CITY OF PORTLAND BUILDING PERMIT

This is to certify that **CHRISTOPHER A. MOONEY** Located At **27 SUNSET AVE**

Job ID: 2011-03-630-SF

has permission to Amend; enlarge deck 2'

**BOUNDARY SURVEY OF LAND ON
SUNSET AVENUE AND CLEEVE STREET,
GREAT DIAMOND ISLAND, PORTLAND, MAINE**

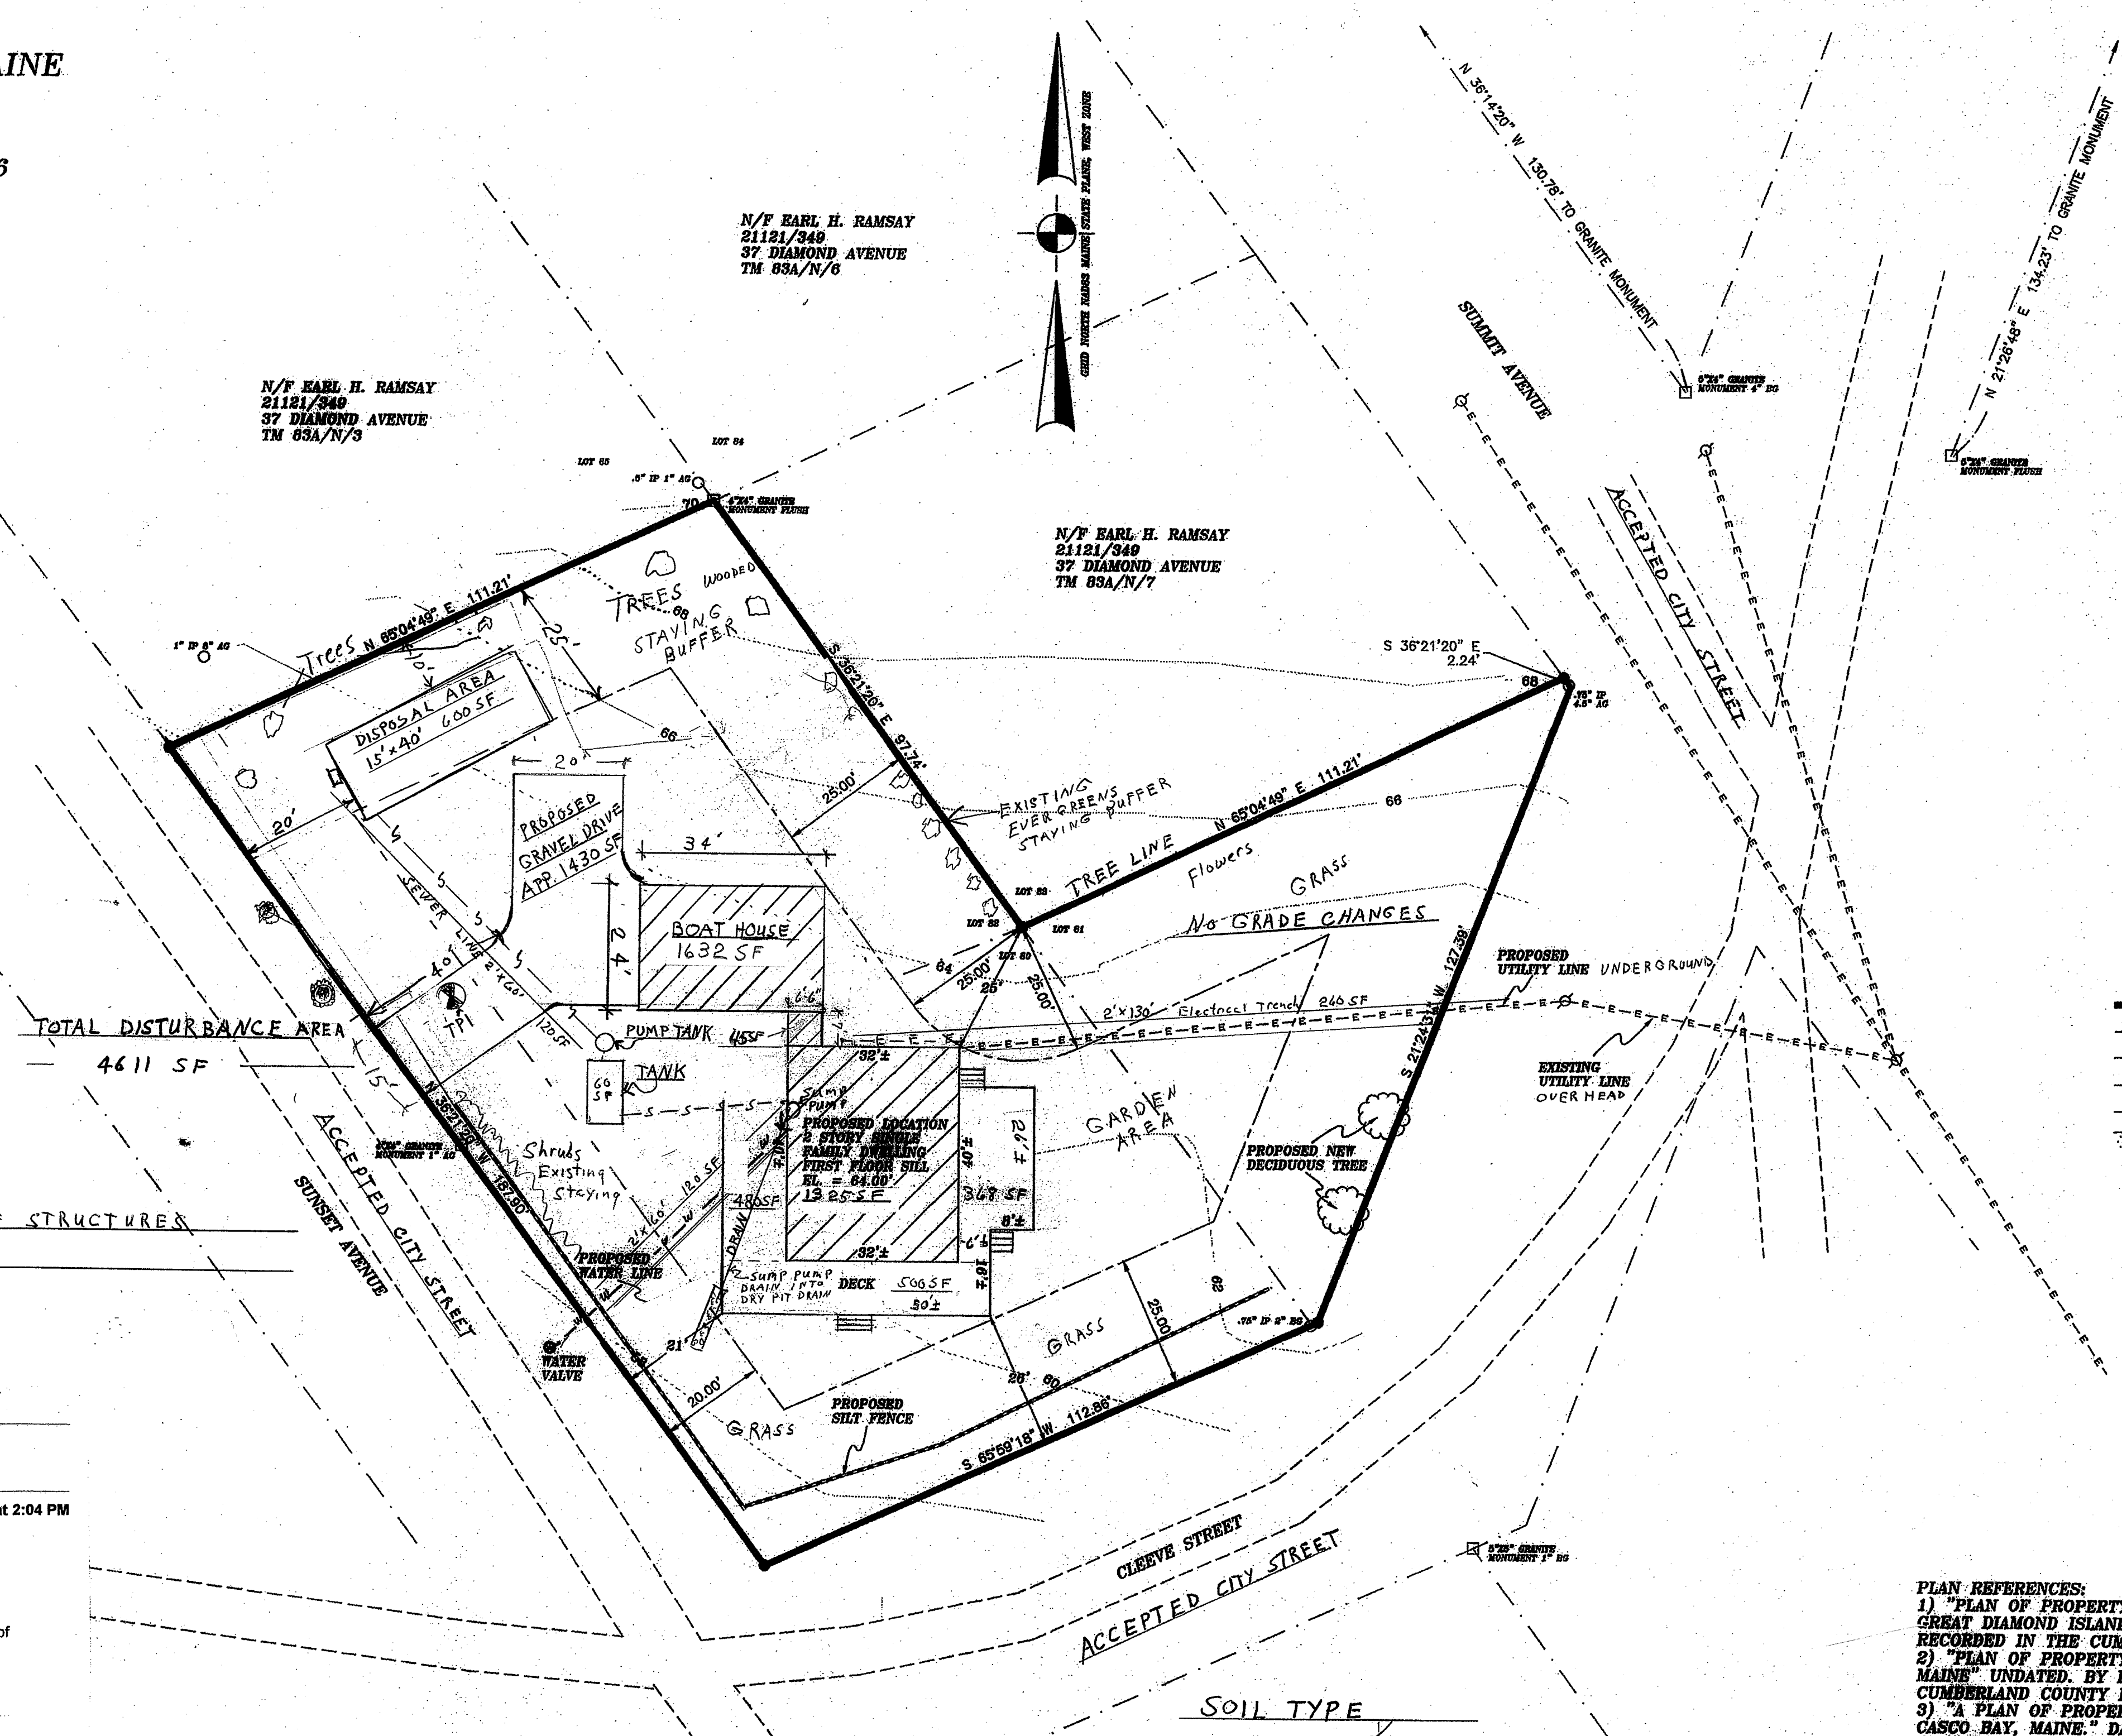
- The size of the left side deck and the stairs off the rear of it do not match between the siteplan and the building plans
- The size of the right side deck and the stairs off both the rear and the side do not match between the site plan and the building plans.
- There are no elevations on the site plan.

5-31-11 Received revised site plan on 5/25/11. Boathouse has been relocated, so it is attached to the house. The relocated boathouse and other information were hand drawn which is not allowed under the site plan criteria. All the information needs to be added by the surveyor with their stamp. The right side deck is still not correct; the size is different between the site plan and the building plans. Waited to call Mike Mooney until today because I needed to check with Phil. Still on hold. - amachado

2ND FLOOR FRAMING PLAN

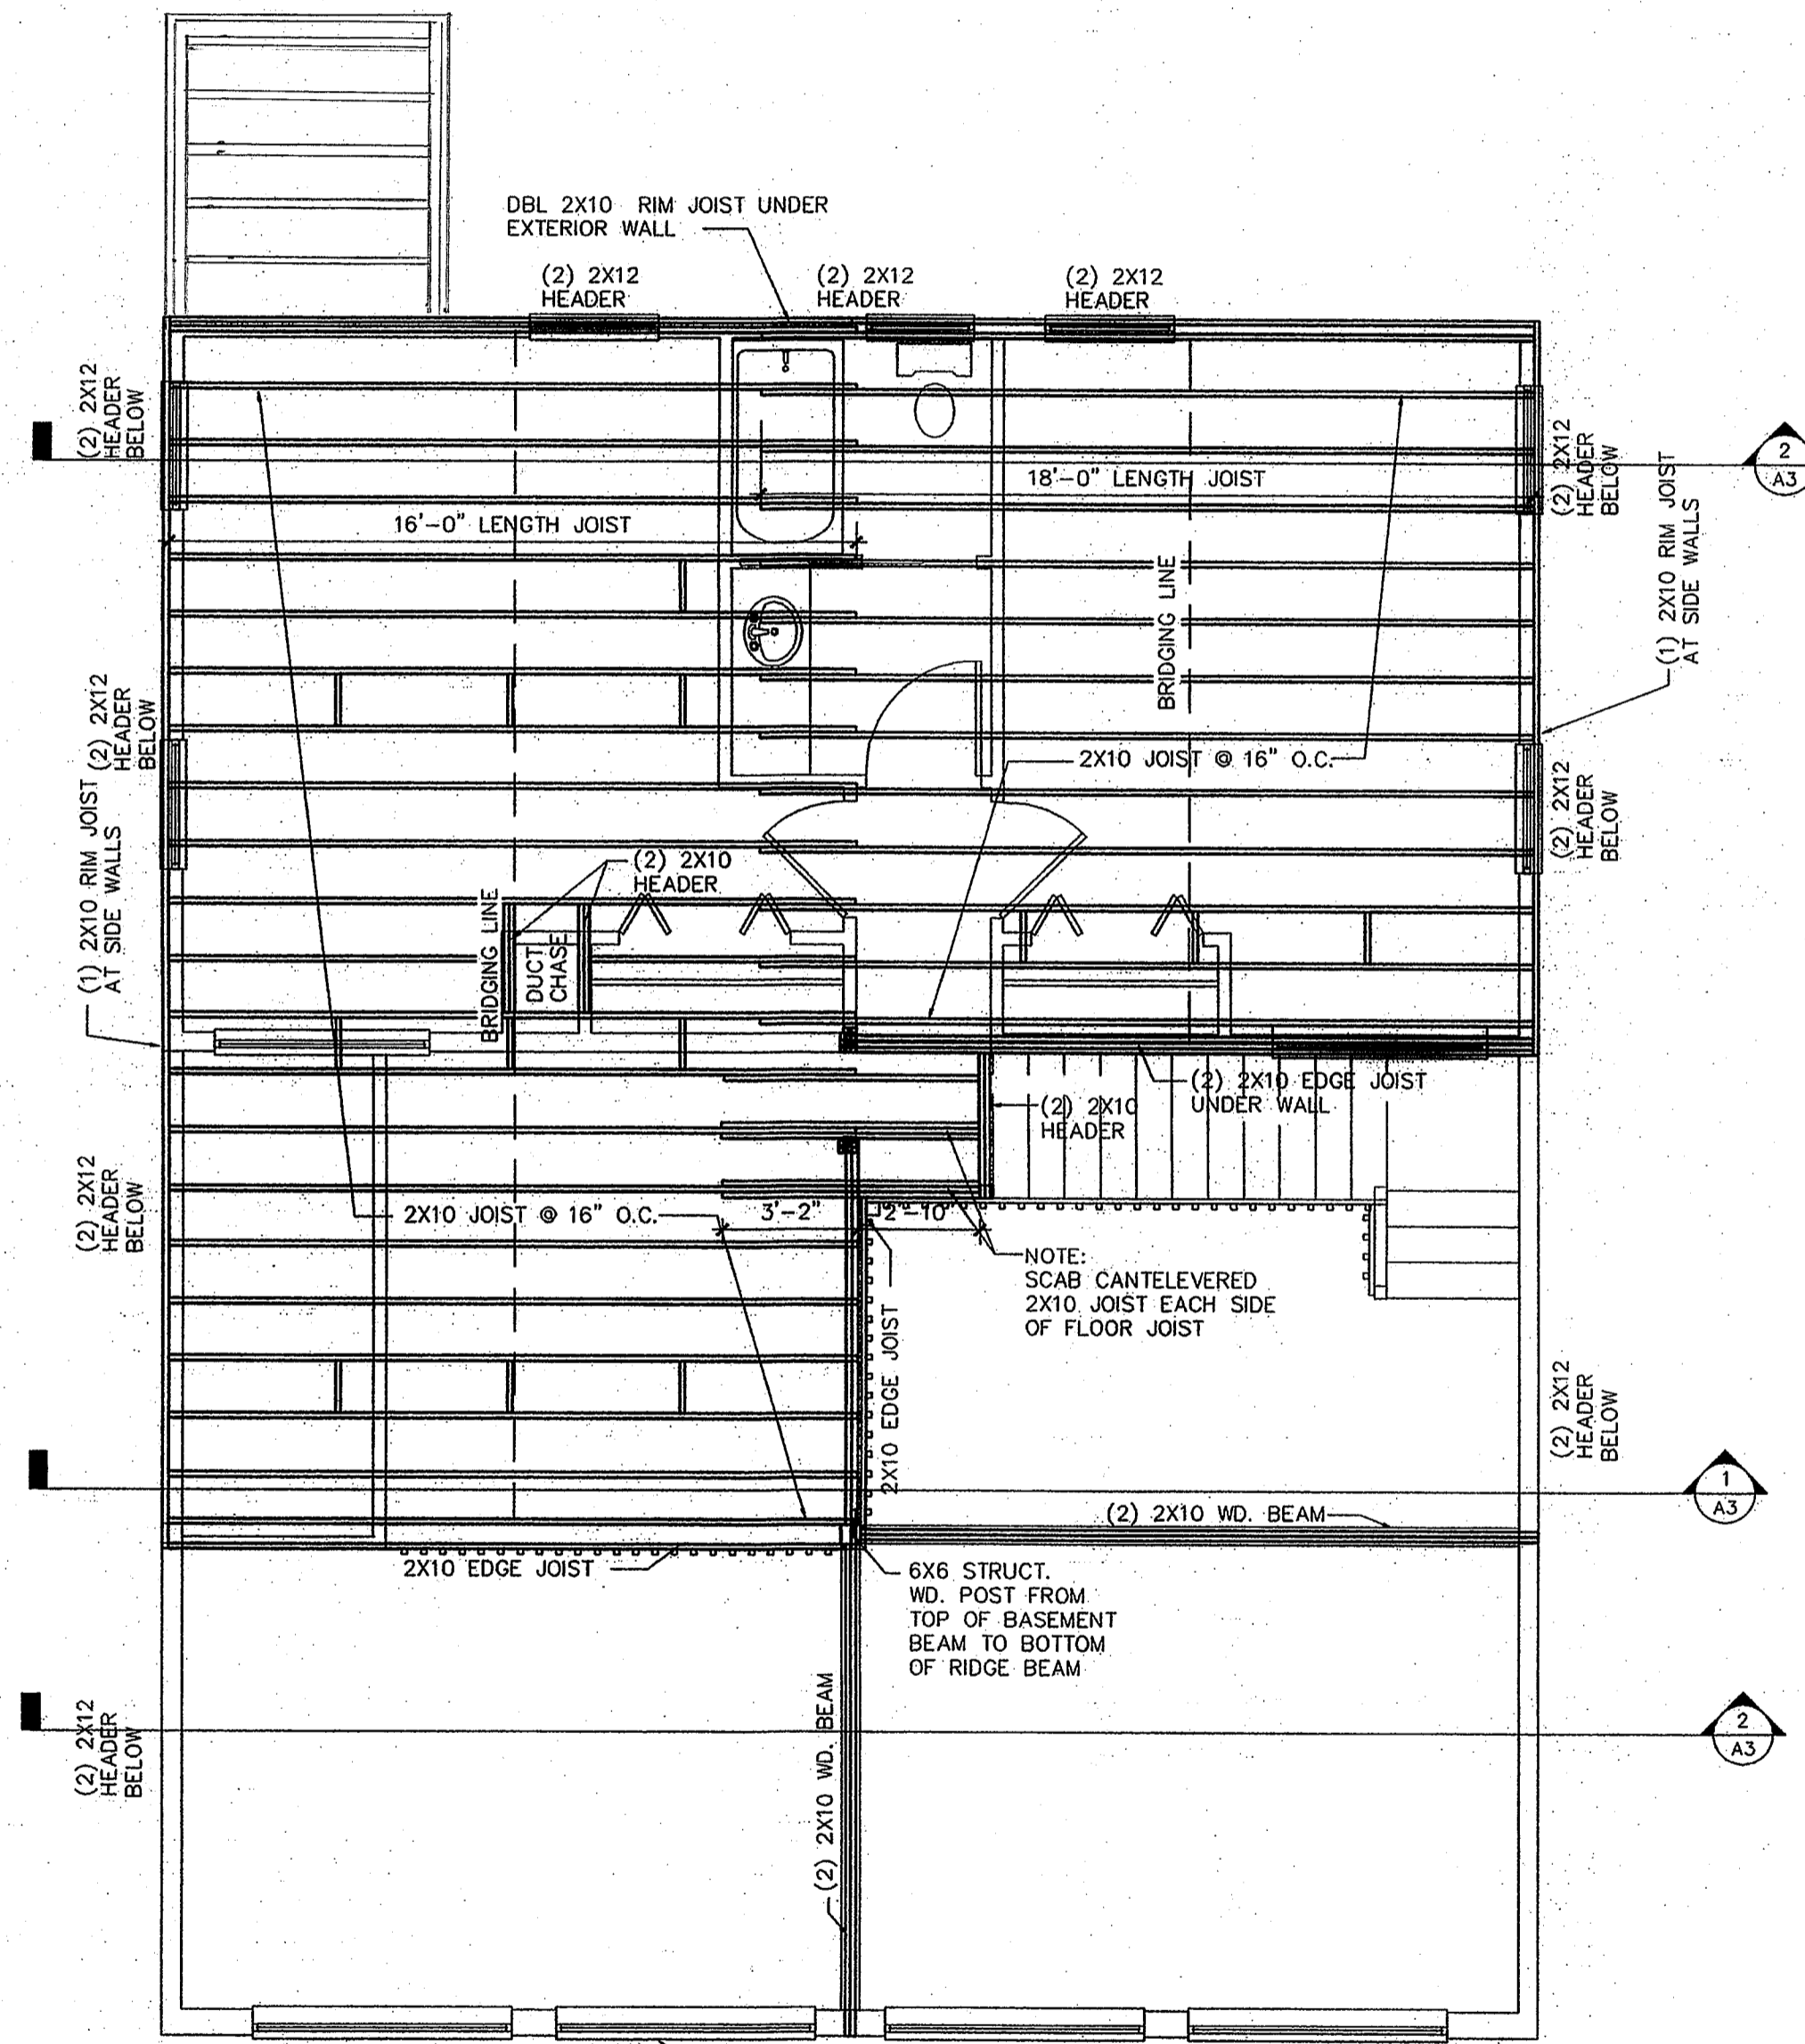
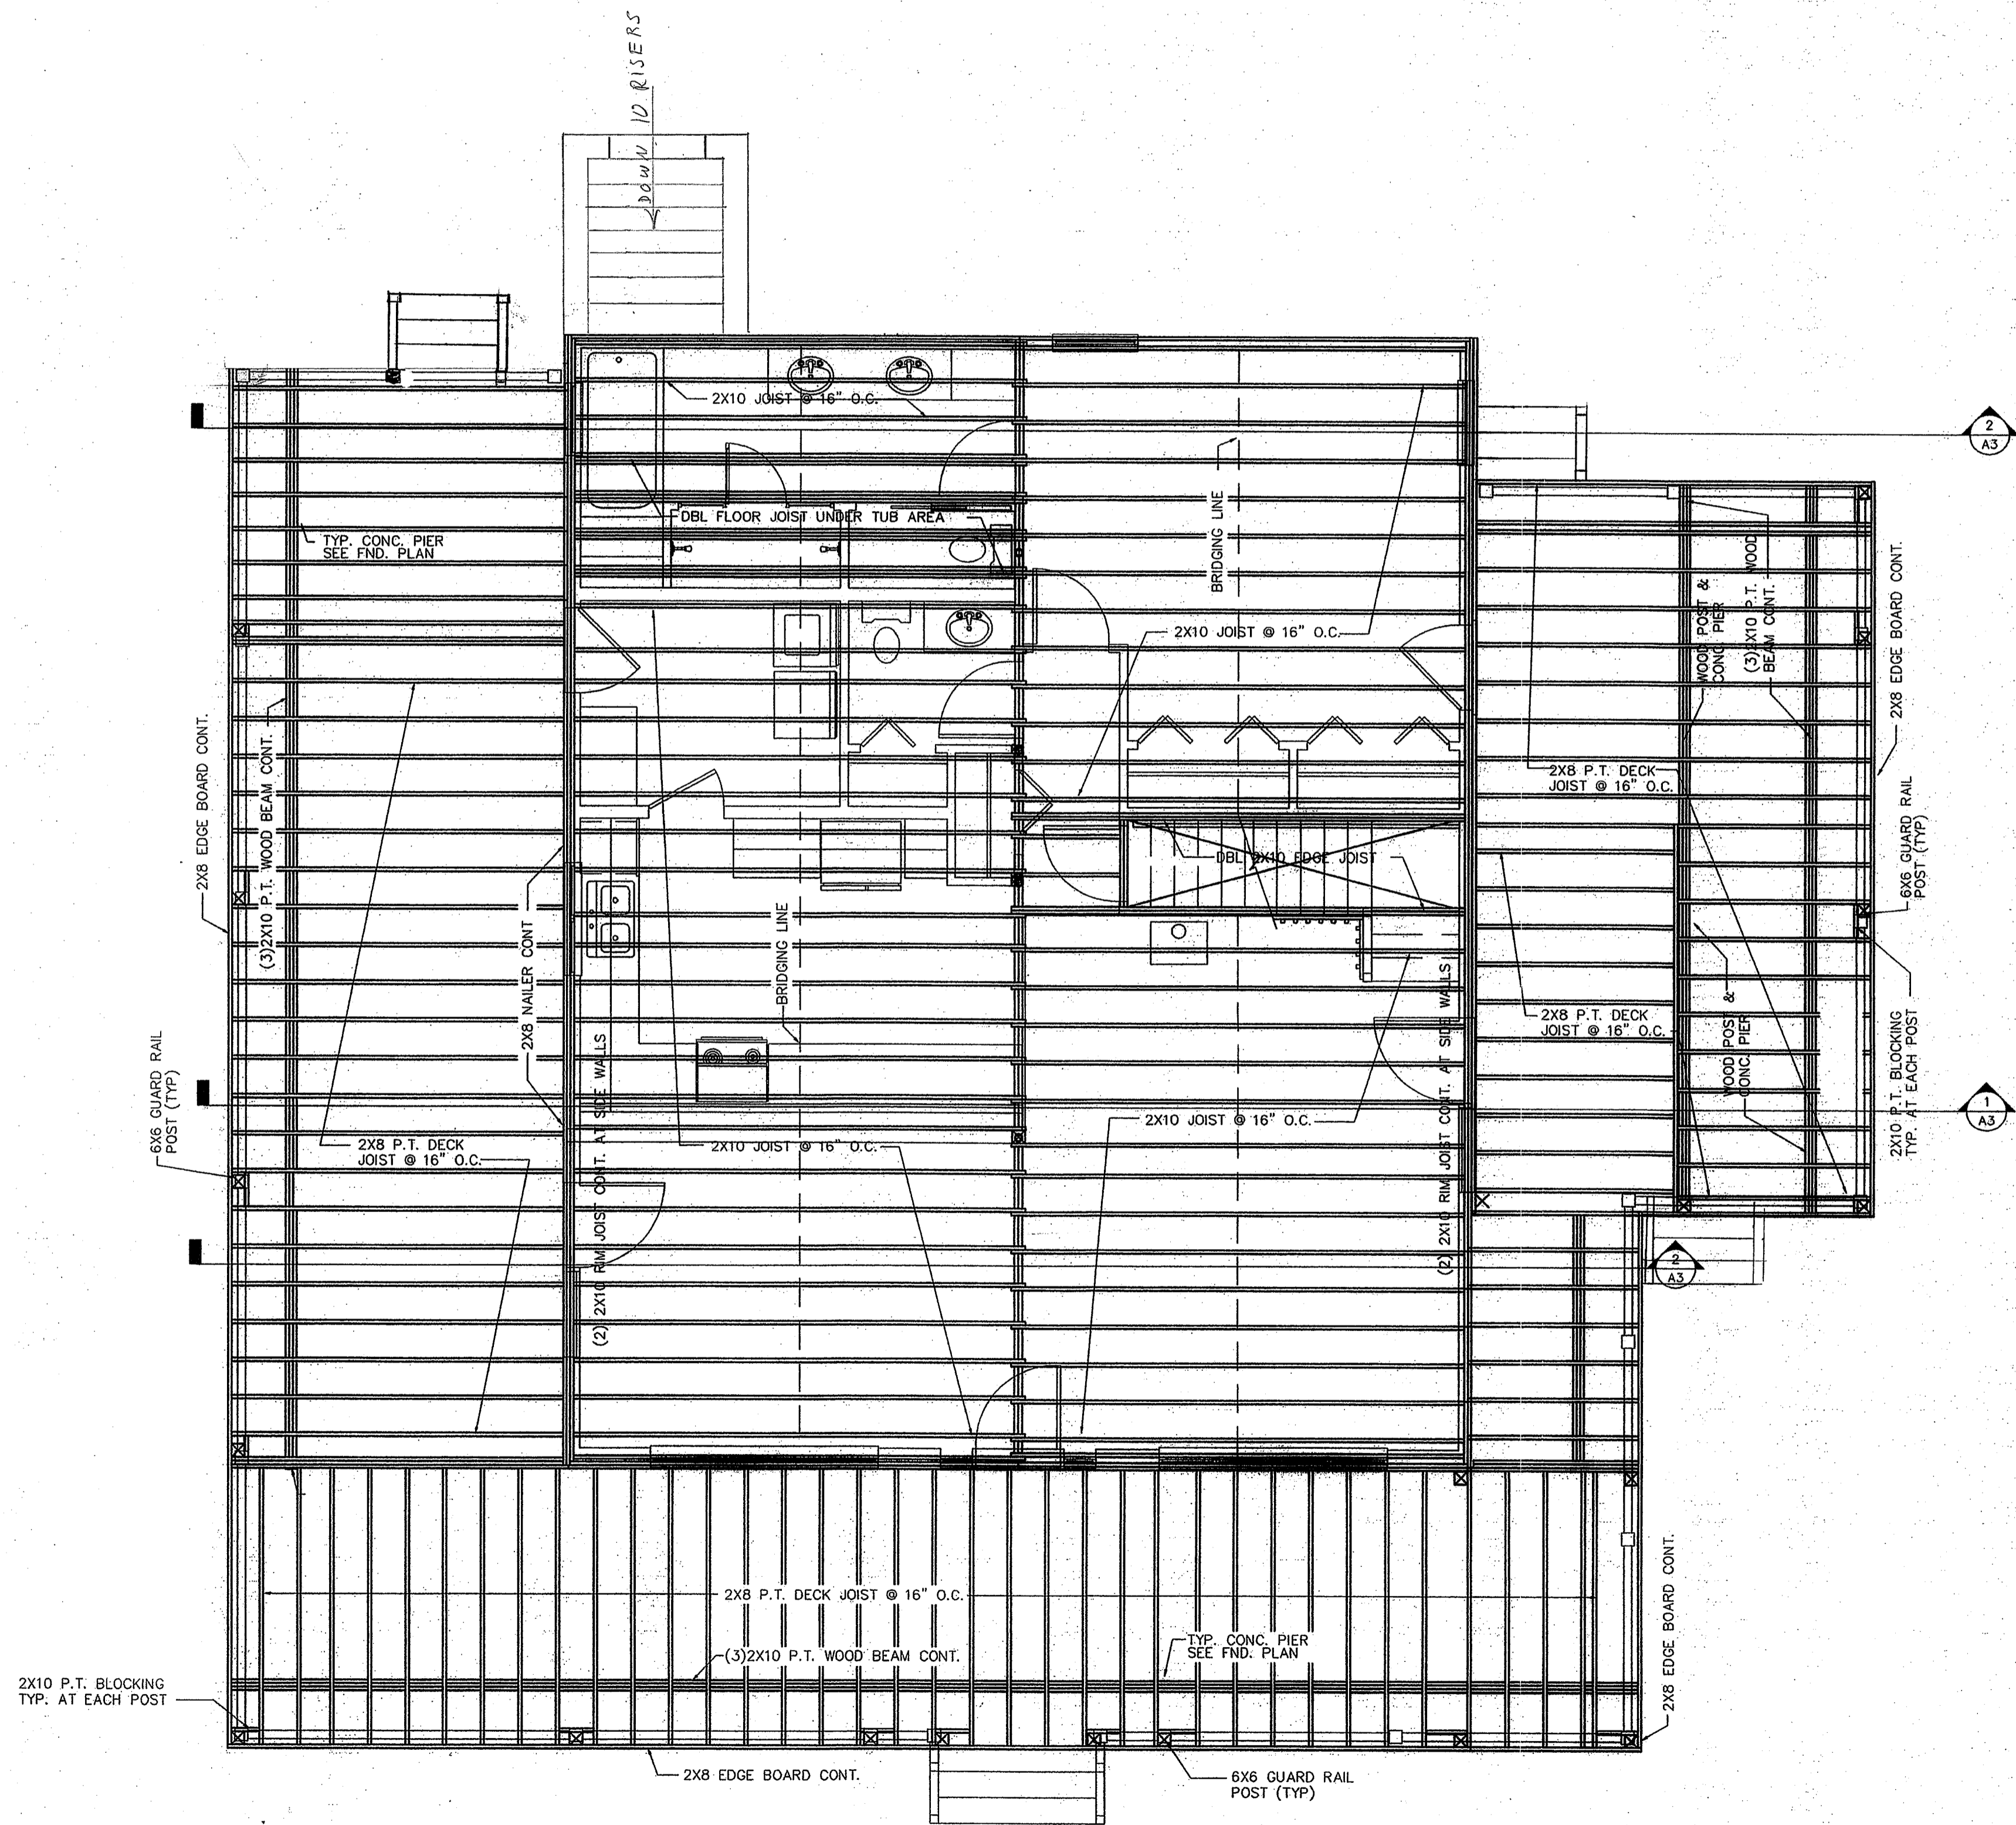
9. Note: See Owner's notations on 2nd floor, floor joist sizes/ span adjustments, and removal of cantilevered floor joist.
